**WELWYN HATFIELD BOROUGH COUNCIL
EXECUTIVE DIRECTOR - PLANNING, PUBLIC PROTECTION AND GOVERNANCE**

Application No: 6/2021/1061/HOUSE
Location: 24 Church Street Hatfield AL9 5AW
Proposal: Installation of 1 x velux conservation rooflight, repairs to front dormer windows, replacement window sills to front elevation, replace canopy to front door, replace front entrance steps and general repair to mortar on front elevation.
Officer: Mrs Sarah Madyausiku

6/2021/1061/HOUSE

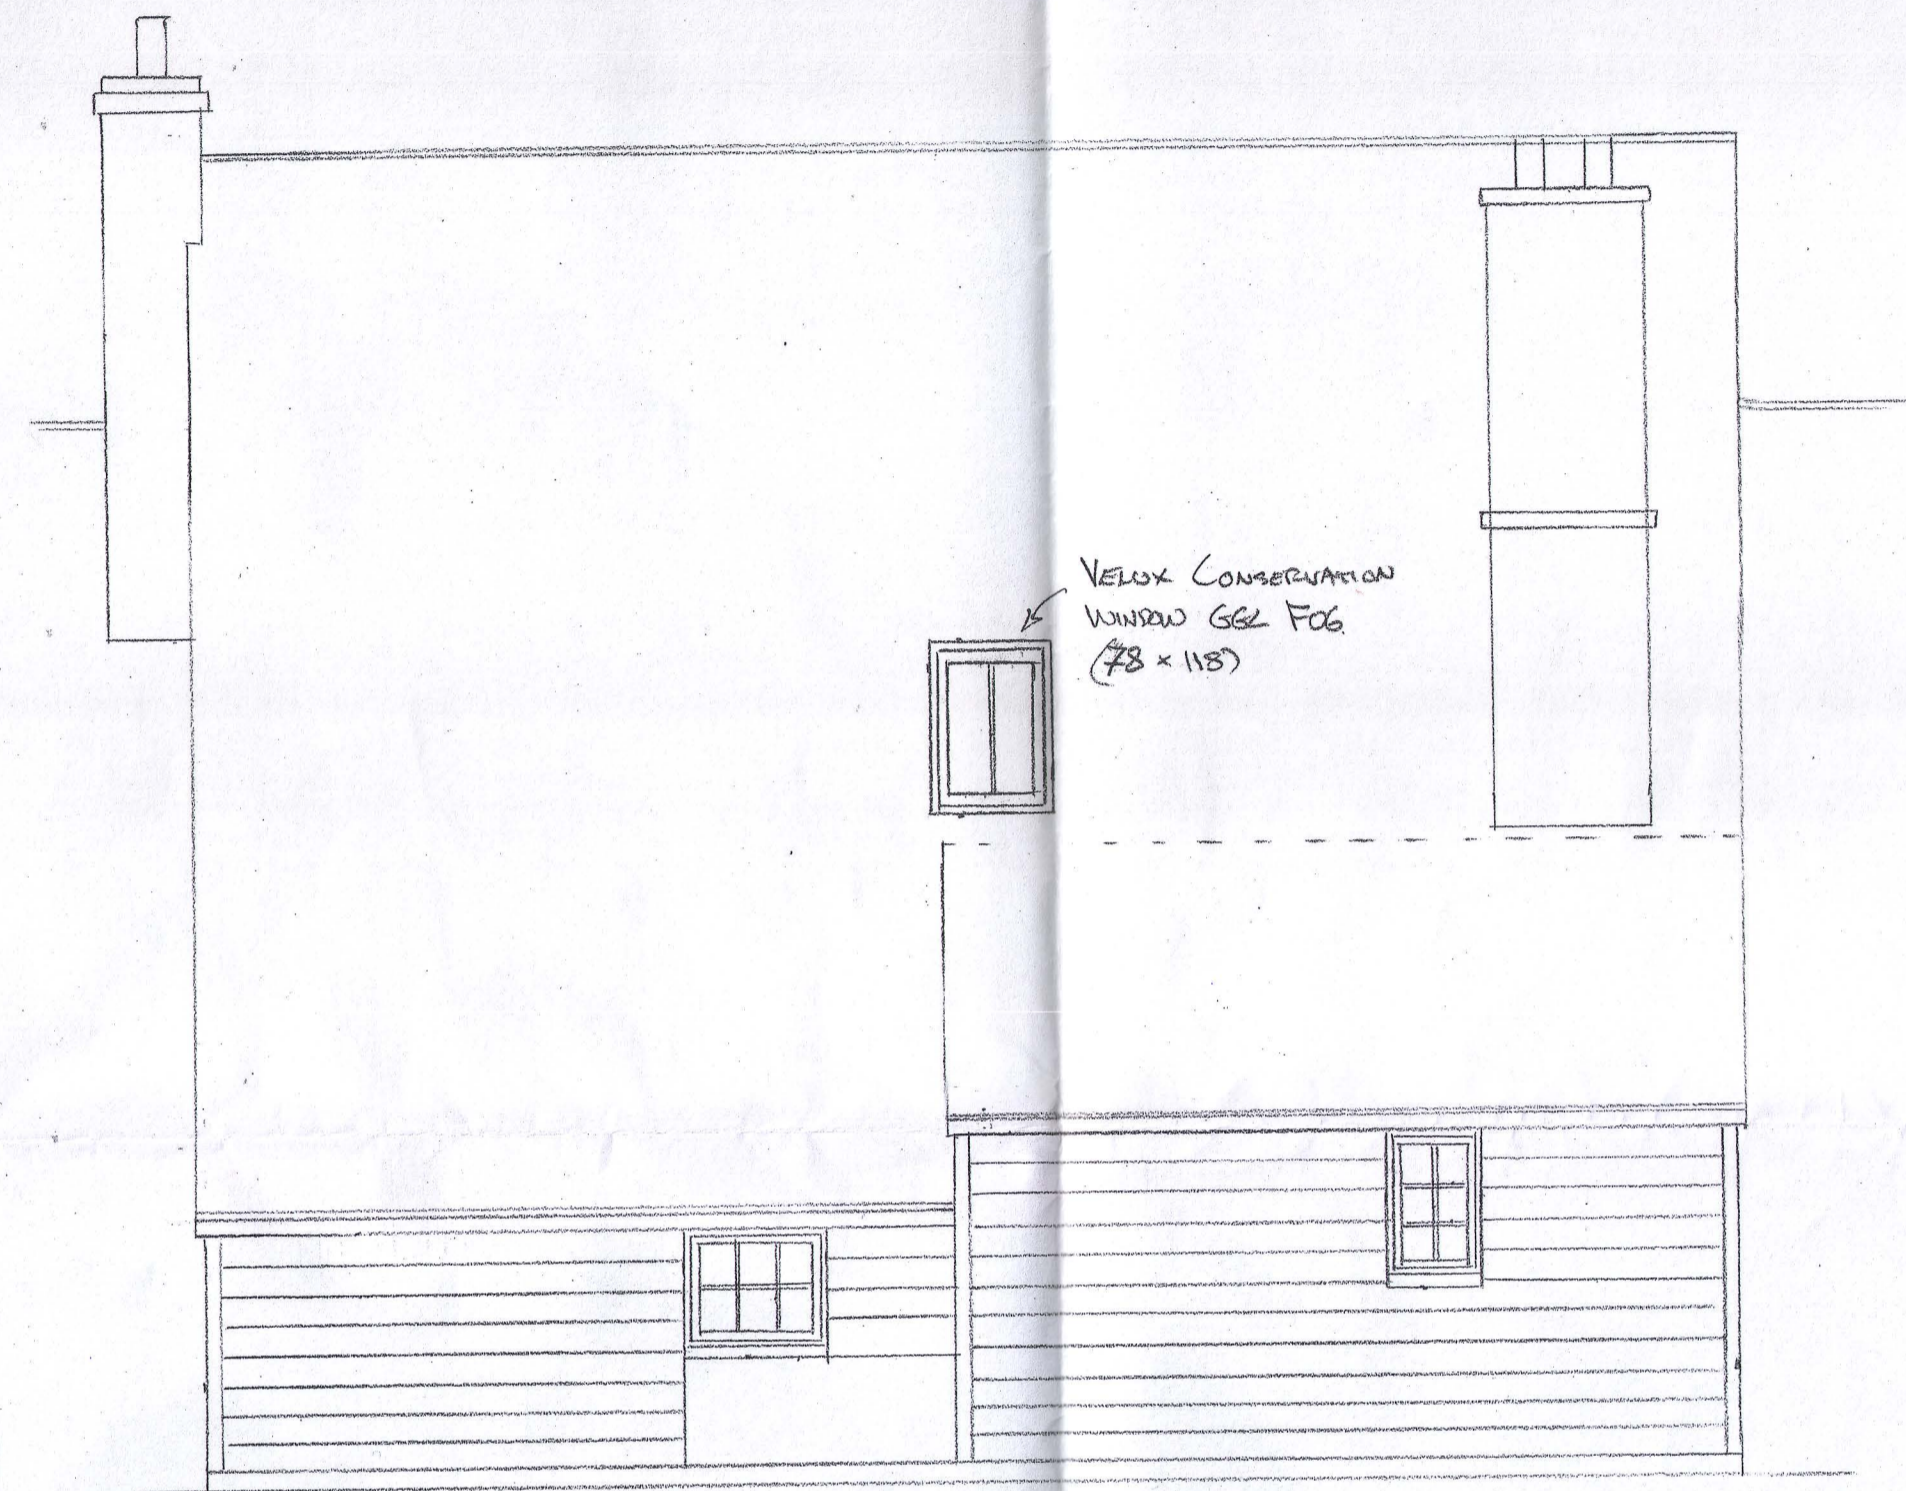
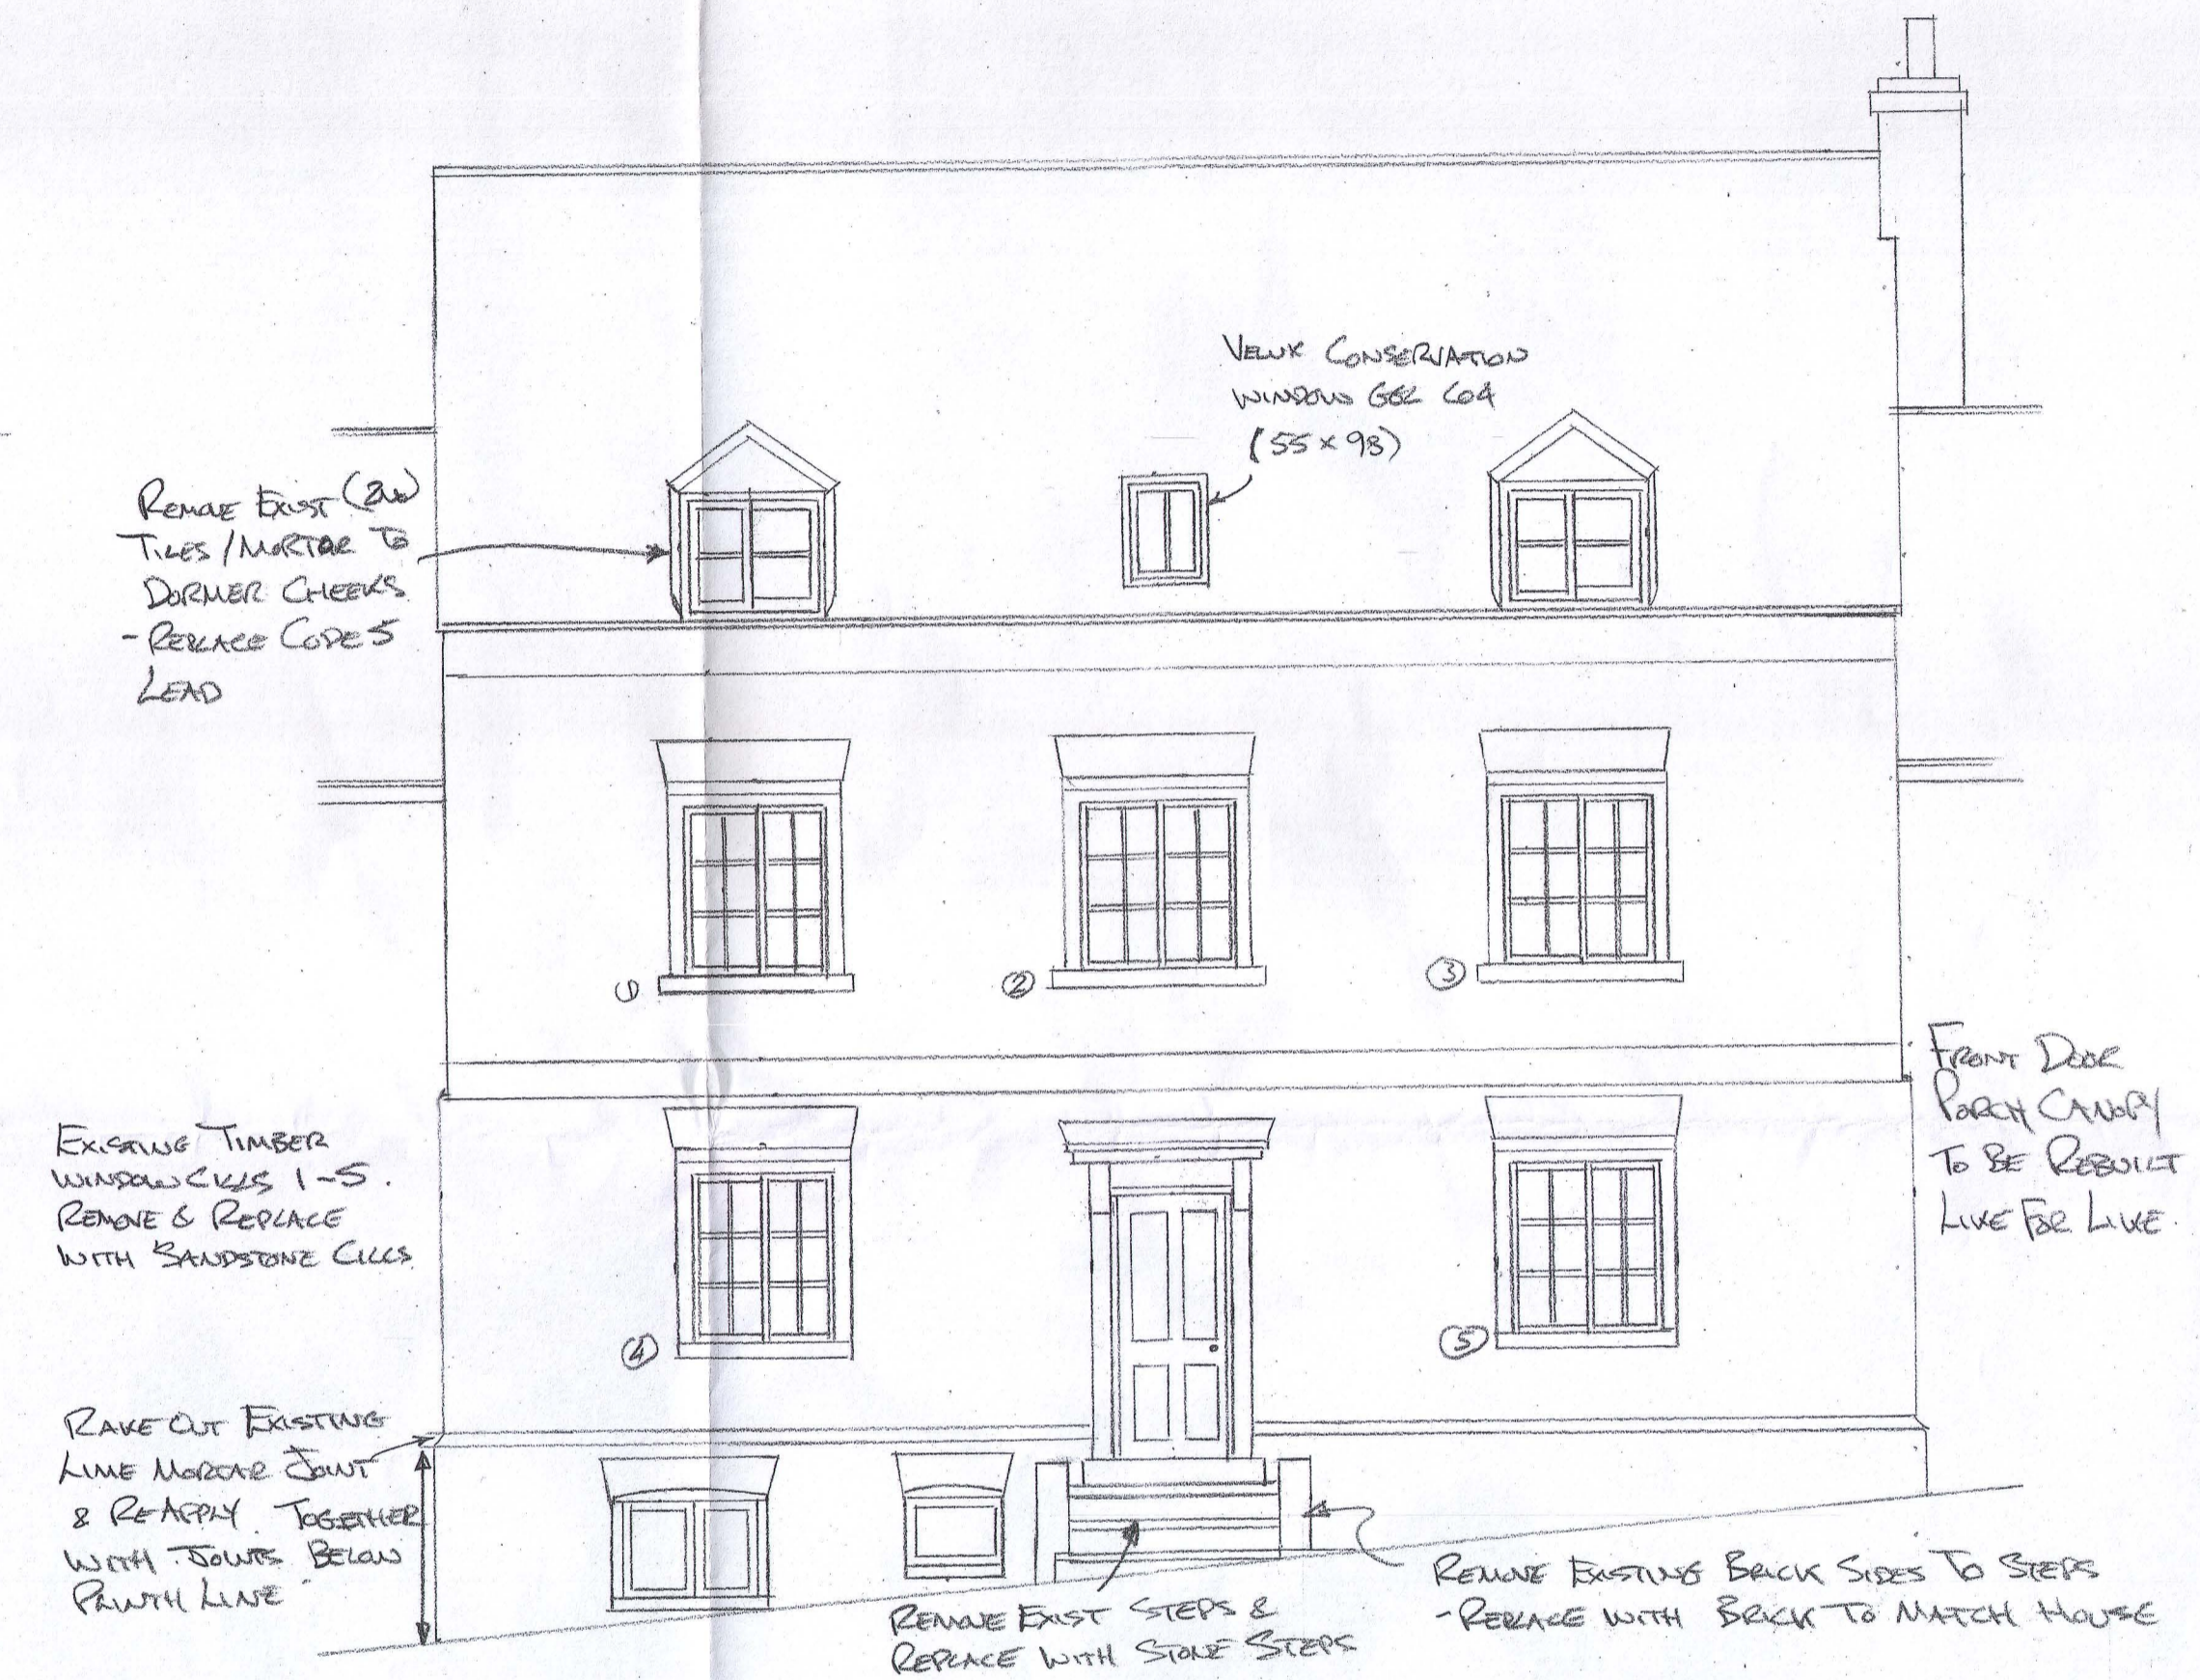
The proposals have been revised to omit the front rooflight (better preserving the traditional appearance of the front roofslope) and to replace the cills with timber rather than stone (timber being a more in keeping with the local vernacular). It has also been confirmed that the rear rooflight will be positioned between existing rafters to avoid the unnecessary loss of historic fabric.

2. The rear rooflight hereby permitted must be positioned flush with the roof tiles. Subsequently, the rooflight shall be retained to be positioned flush with the roof tiles.
